**From:** Rhiannon Lloyd  
**Sent:** 25 November 2025 15:47  
**To:** Planning.Responses  
**Subject:** FW: FP/148/25/HH - 2 ORMESBY CRESCENT - SUB PLANS  
**Attachments:** 2502 P 05 Elevations as Proposed 25 11 25.pdf; 2502 P 04 Plans as Proposed 25 11 25.pdf; 2502 P 03 Elevations as Existing 25 11 25.pdf; 2502 P 02 Plans as Existing 25 11 25.pdf; 2502 P 07 Perspective Views 25 11 25.pdf; Action Sheet FP 148 25 HH.docx

### FP/148/25/HH

**Subject:** FP/148/25/HH - 2 ORMESBY CRESCENT

Ground Floor Plan

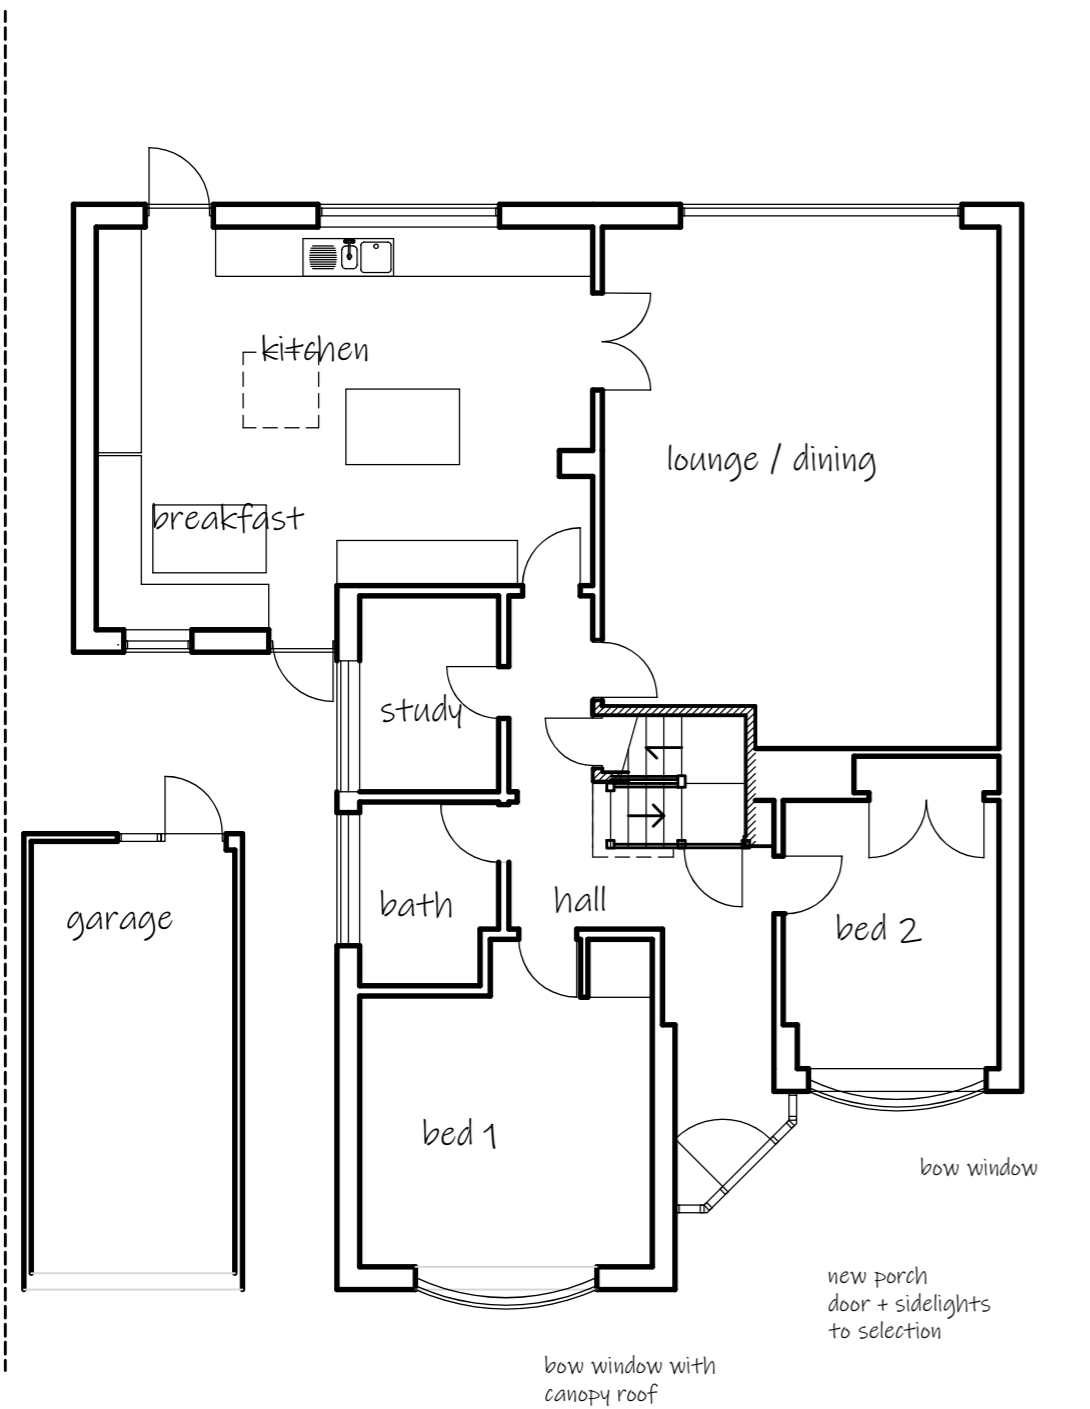
However, I refer to the ground floor window with the canopy roof on the west elevation, not the dormer. The plans suggest it serves bedroom 1 on the ground floor.

West Elevation

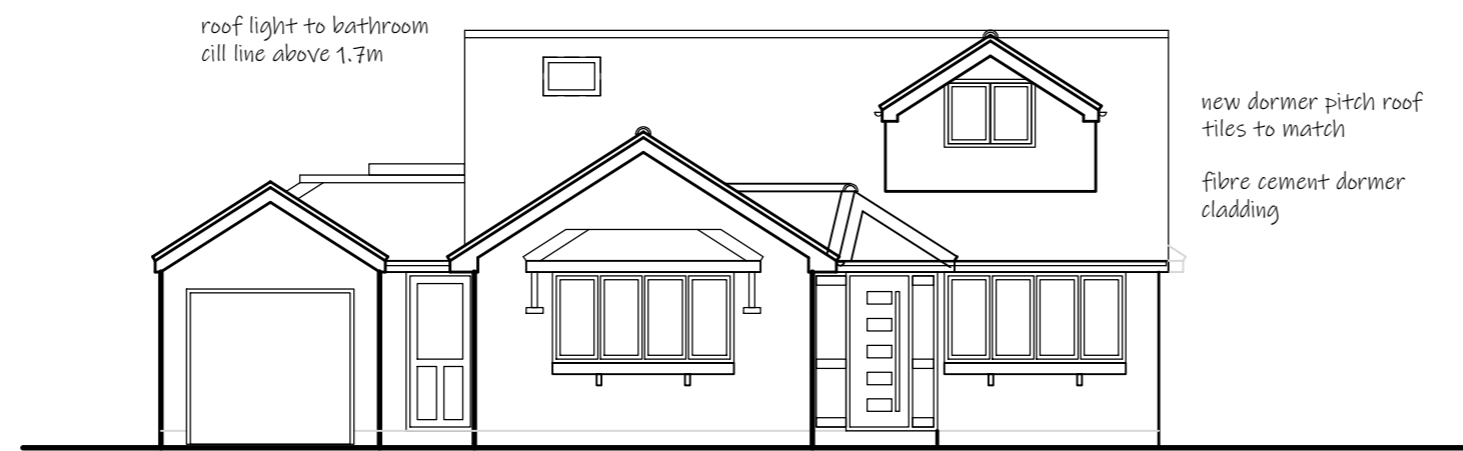
This is the window I suggest is centralised. Please confirm whether you intend to amend the plans.

I notice that the bay window within the front elevation is slightly off centre. I am unsure if this is intentional. Please could the plans be amended to show the window and canopy as centralised within this element of the elevation.

Thank you for clarifying, attached amended plans and elevations
